WEST SUSSEX COUNTY COUNCIL CONSULTATION

TO:	Arun District Council FAO: Claire Potts
FROM:	WSSC - Highway Authority
DATE:	11 February 2022
LOCATION:	Woodgate Centre Oak Tree Lane Chichester PO20 3GU
SUBJECT:	AL/107/21/PL Demolition of the Woodgate Centre buildings (including 3 No. residential dwellings) & the construction of 180 No. residential dwellings with the creation of new vehicular access with footways and cycleways, ancillary road infrastructure, emergency access arrangements, associated parking, public open space, including children's play space, landscape planting, surface water attenuation & drainage & other associated infrastructure. This site is in Cil Zone H SP2, BEW Strategic Site and is not CIL Liable. Additional information received
DATE OF SITE VISIT:	10th September 2021
RECOMMENDATION:	No Objection (subject to suitable S106 and conditions)
S106 CONTRIBUTION TOTAL:	SEE BELOW (NON-HIGHWAYS INFRASTRUCTURE LIST AND FINANCIAL AMOUNTS TO BE PROVIDED SEPARATELY)

This is the third WSSC Highways (CHA) response to the above planning application for demolition of the Woodgate Centre buildings (including 3 No. residential dwellings) and the construction of 180 No. residenti

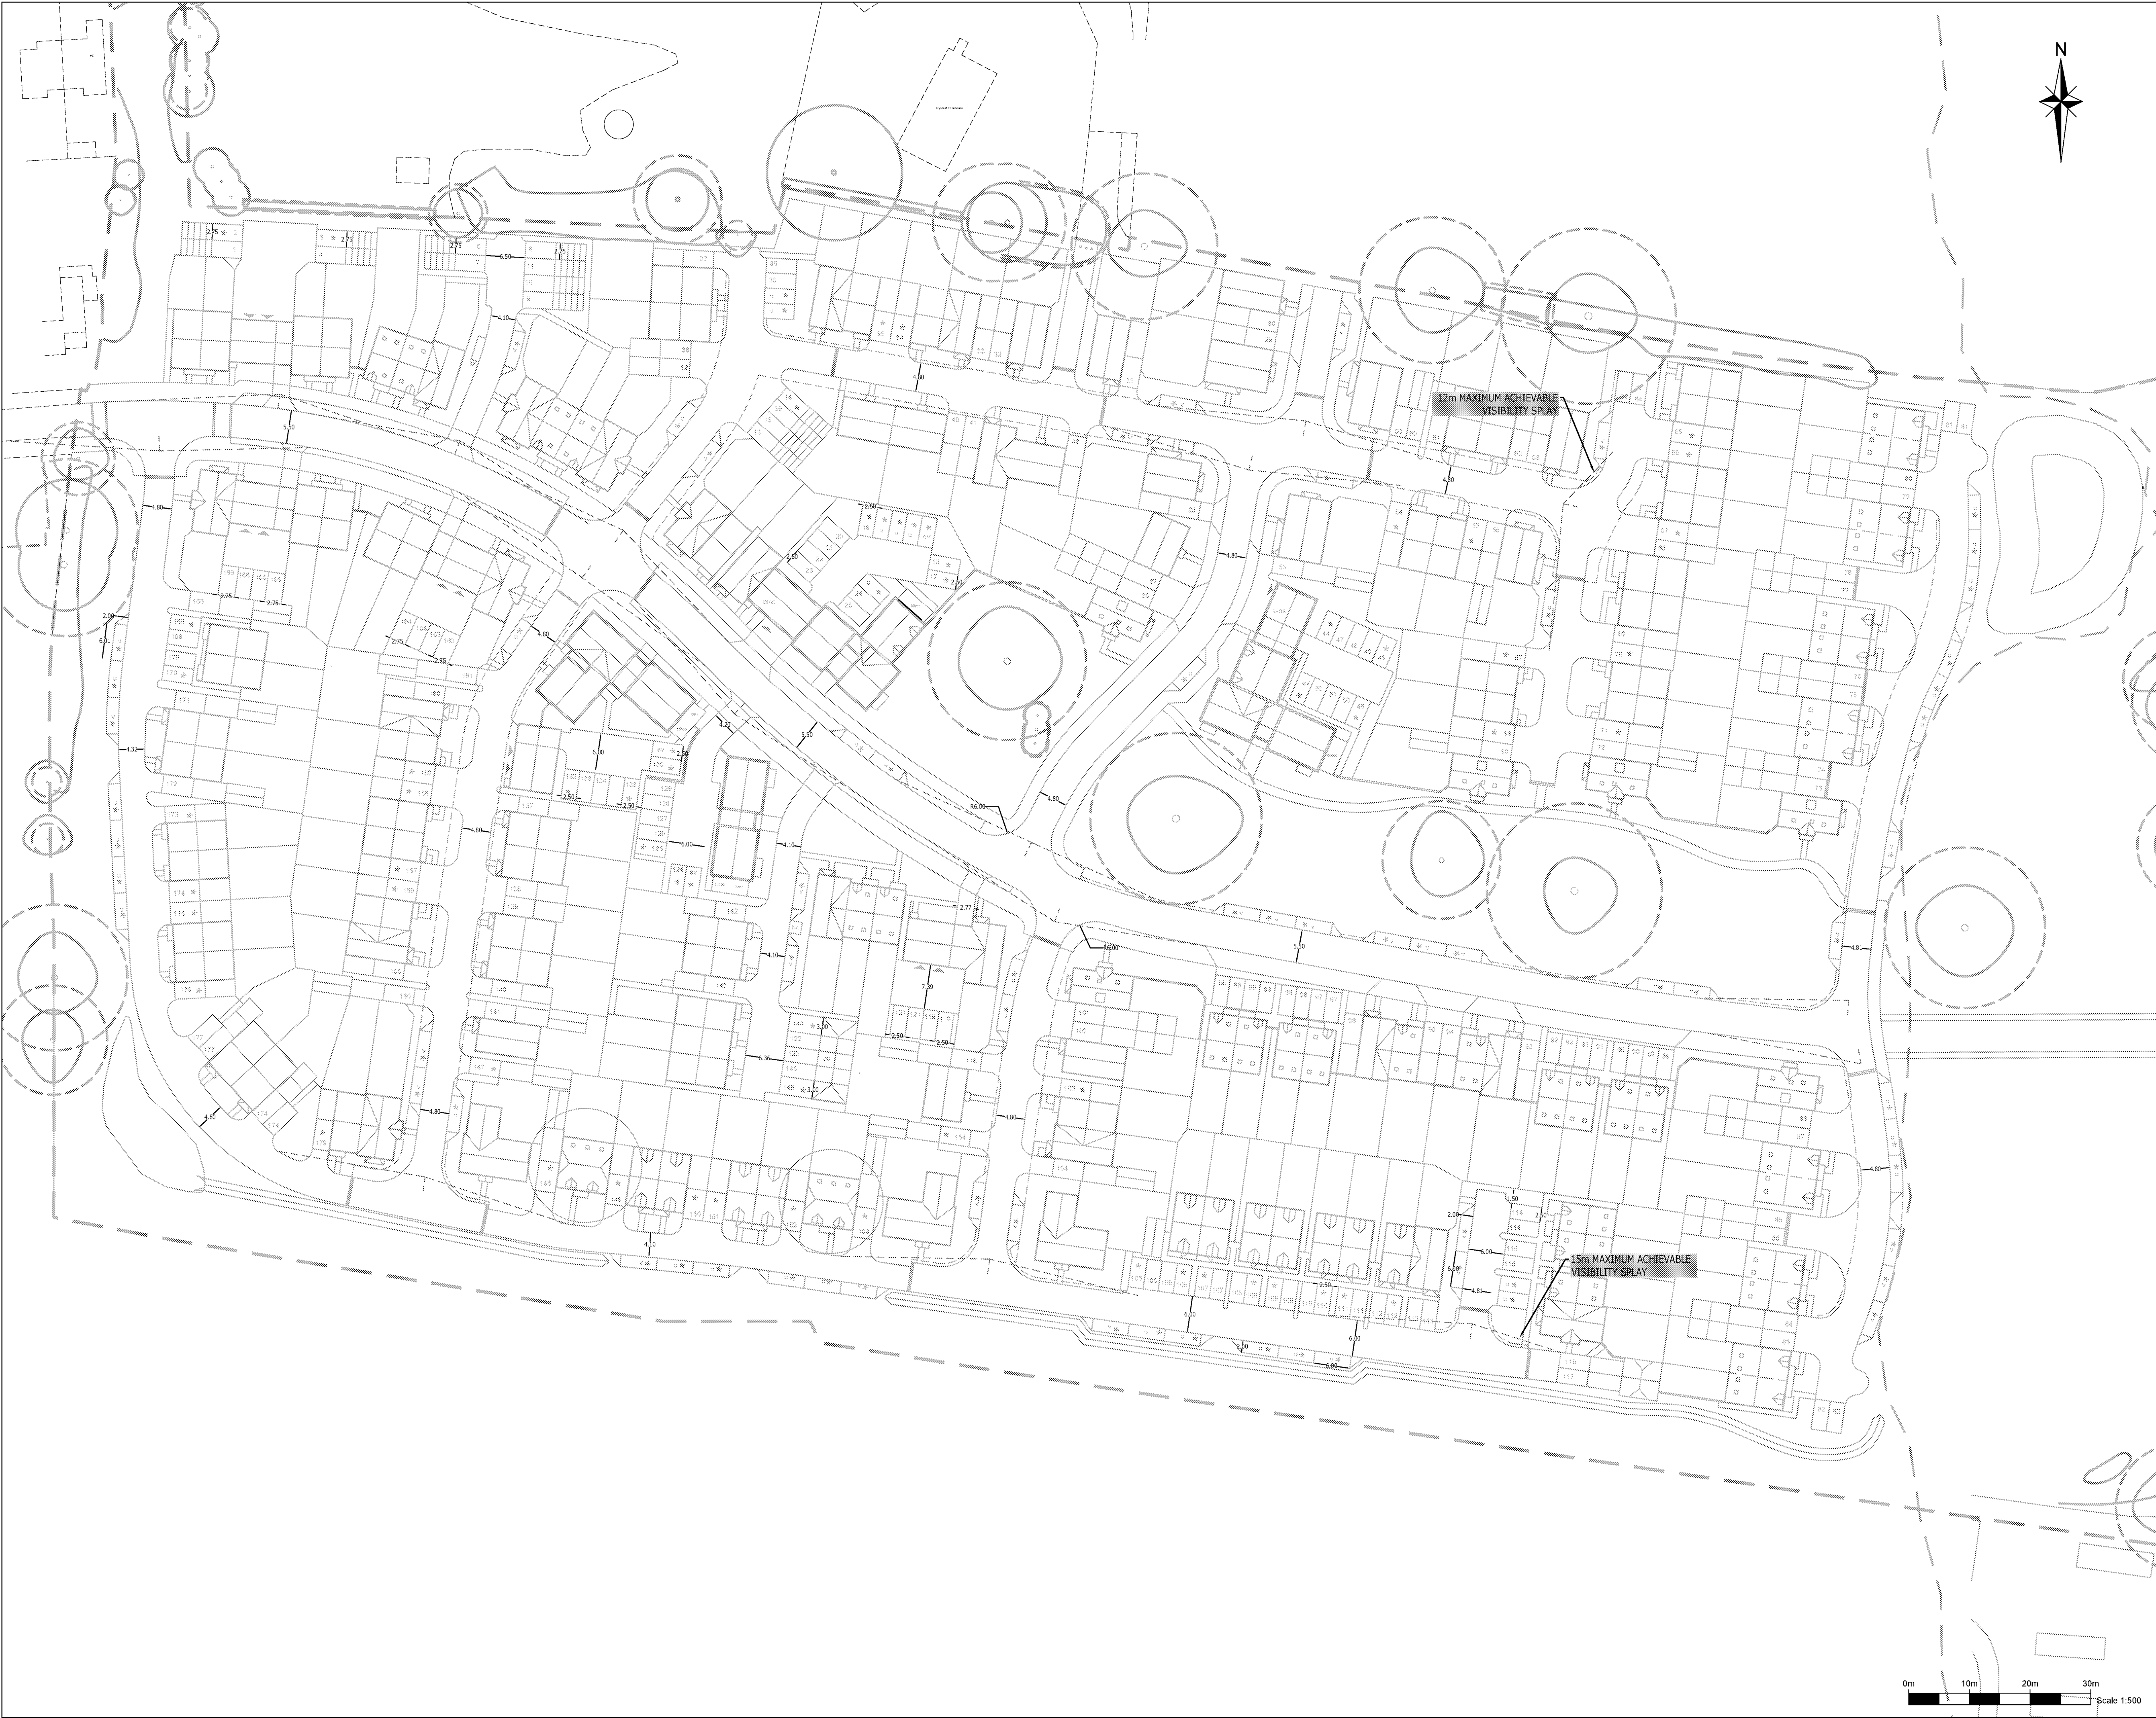
Please see comments made in point 1 above. Please also note the Road Safety Audit recommendation about curtailing the route on the western side of A29 Lidsey Road.

Specifically with regard to item 2.2 in the Road Safety Audit, the CHA still considers that the audit team recommendation of terminating the route south of the railway crossing be pursued for the reasons already given (please see WSCC response dated 17th September 2021). Should the applicant disagree with this then a formal 'Exception' would need to be considered by the CHA. Comment about 2.5m being a minimum rather than fixed width for the route is noted.

The applicant has now curtailed the route and this is shown on Drawing No. 20-61-014 Revision J. The CHA also notes that some other changes have been made (namely an advance stop line for cycles in the NB direction and an exit point and approach lane for cyclists to join the proposed shared foot/cycleway on the eastern-side of the road). As these haven't been considered through the Stage 1 Road Safety Audit (RSA) process they will be subject to scrutiny (and possibly changes) through the S278 Design Checking and Stage 2 RSA processes should planning permission be granted for the development.

The applicant has now curtailed the route and this is shown on Drawing No. 20-61-014 Revision J. This is now shown on Drawing No. 20-61-014 Revision J. The CHA also notes that some other changes have been made (namely an advance stop line for cycles in the NB direction and an exit point and approach lane for cyclists to join the proposed shared foot/cycleway on the eastern-side of the road). As these haven't been considered through the Stage 1 Road Safety Audit (RSA) process they will be subject to scrutiny (and possibly changes) through the S278 Design Checking and Stage 2 RSA processes should planning permission be granted for the development.

TYPICAL CENTRAL PIER SECTION
SCALE 1:25

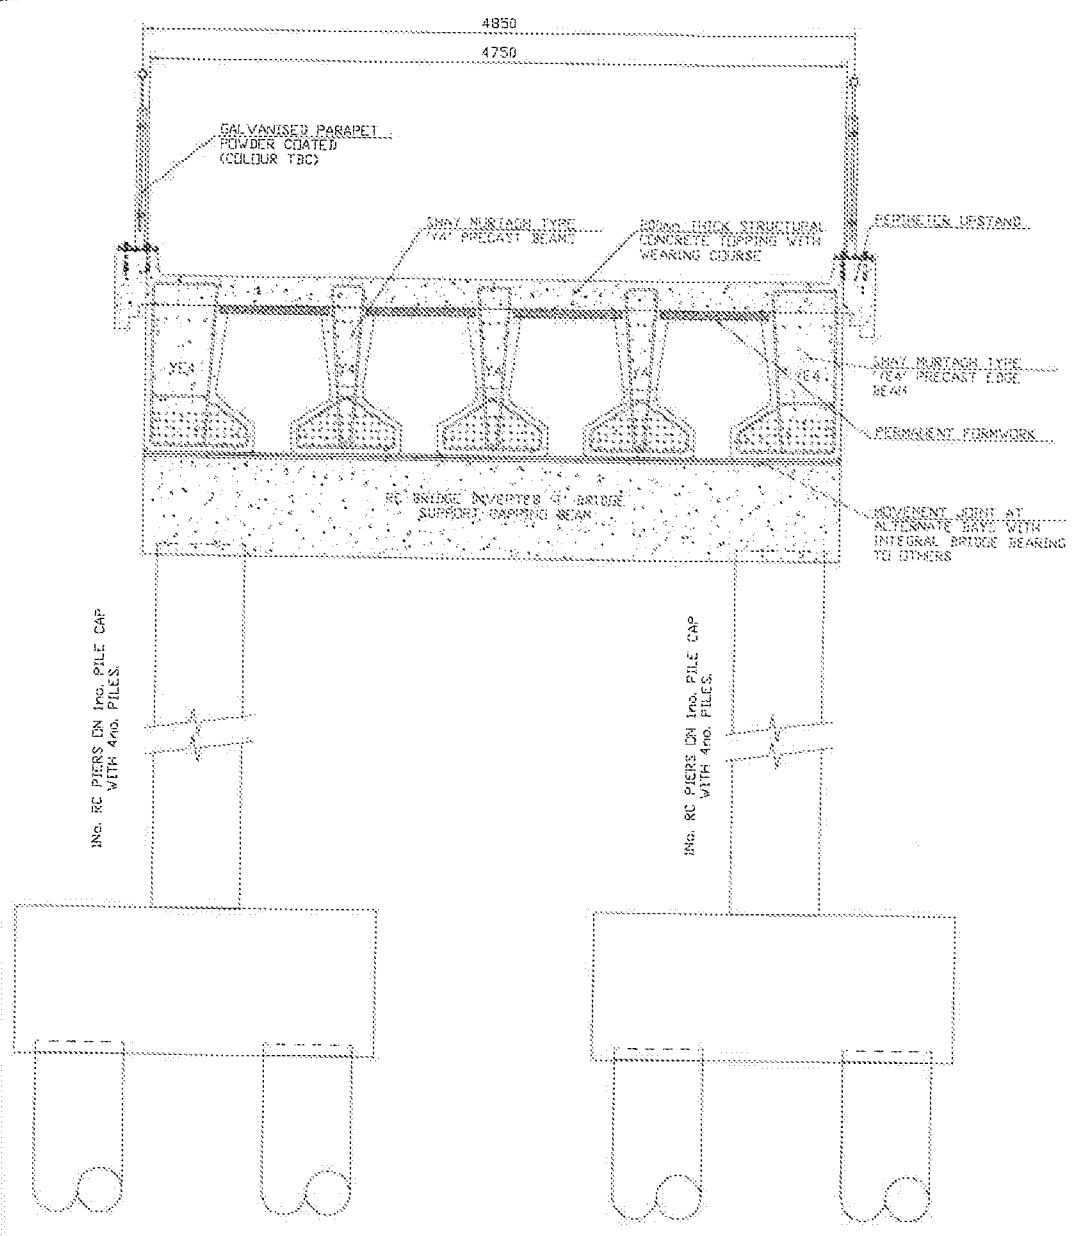
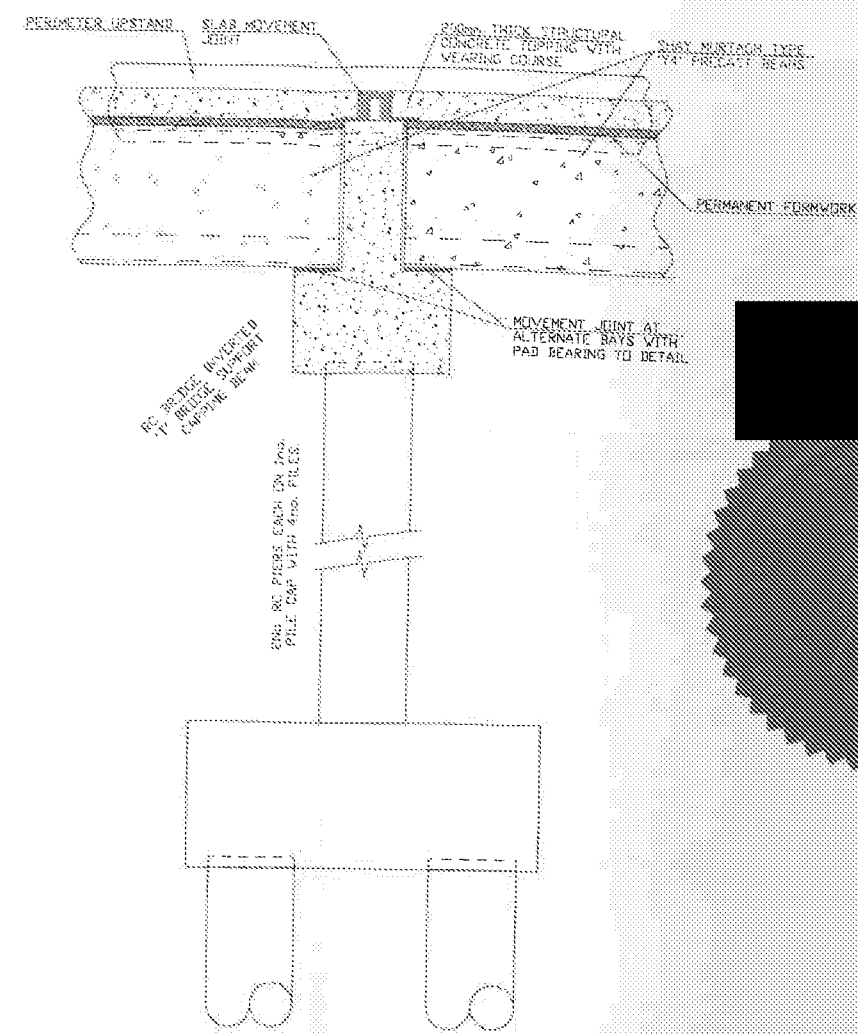
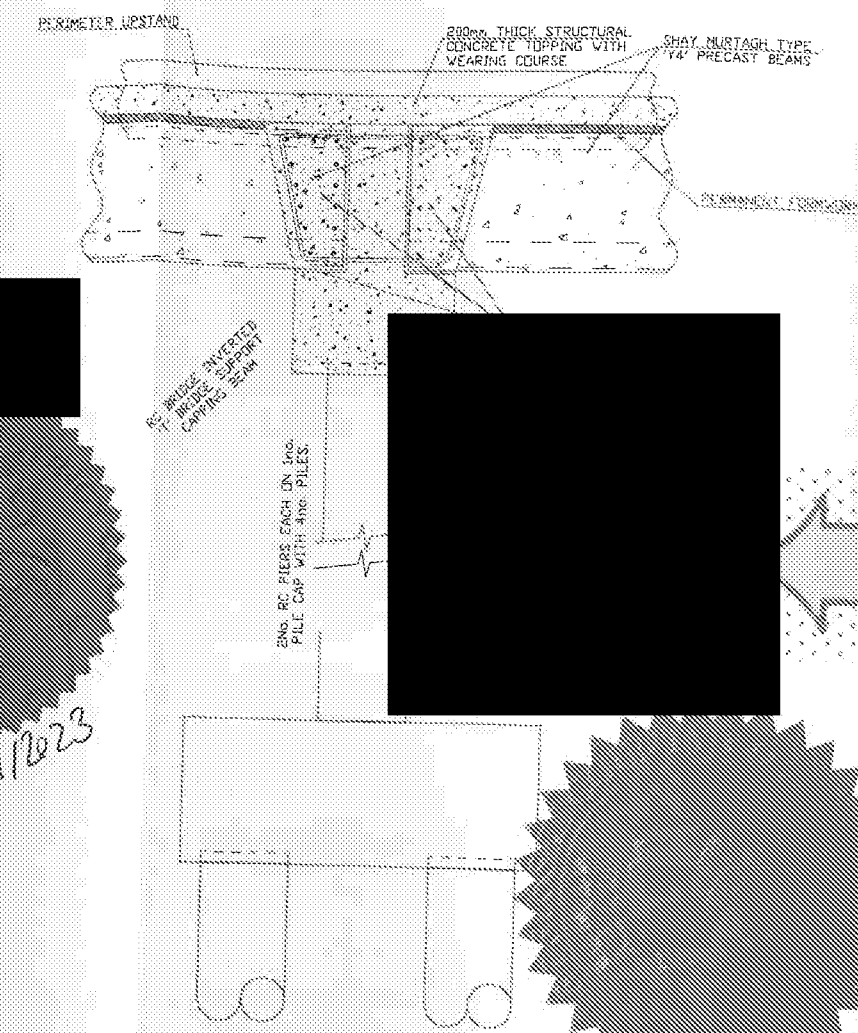
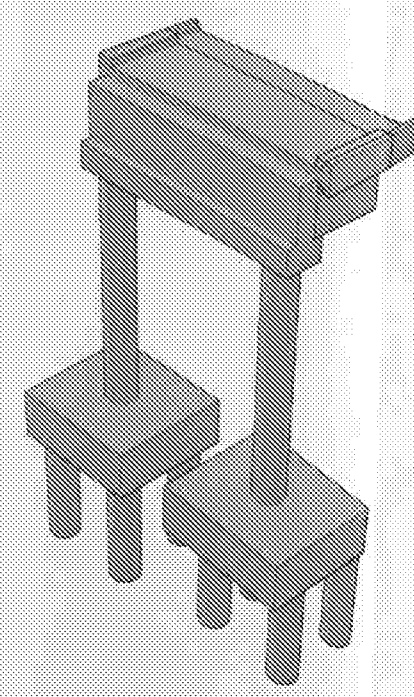
Given the above, it might also require the adjacent developer/s to be party to the S106 Agreement too. For avoidance of doubt, the CHA has not checked the construction details of the bridge in detail. Therefore, the applicant should not consider that any construction details submitted so far would be acceptable. Detailed assessment would be undertaken at the point of submission of detailed plans post-planning or other future date. However, some points of principles are set out below.

With regards to the principle and format of the structure, the principle of the structure is acceptable subject to the final version being suitable for joint walking and cycling. An AIP will be required in due course, but until such a point the developer / designer should consider the following broad guidance points for the detailed design:

- 1. The clear width of the structure must be carefully considered in conjunction with guidance given in LTN 1/20.*

2. *Bearings and expansions joints are to be avoided wherever possible as these add to WSCC maintenance burden that will otherwise need to be reflected in the commuted sum.*
3. *Paintwork is to be avoided wherever possible as this also adds to the WSCC maintenance burden that will otherwise need to be reflected in the commuted sum. Materials with none or negligible maintenance liabilities are preferred such as concrete, weathering steel, galvanised steel, FRP etc.*
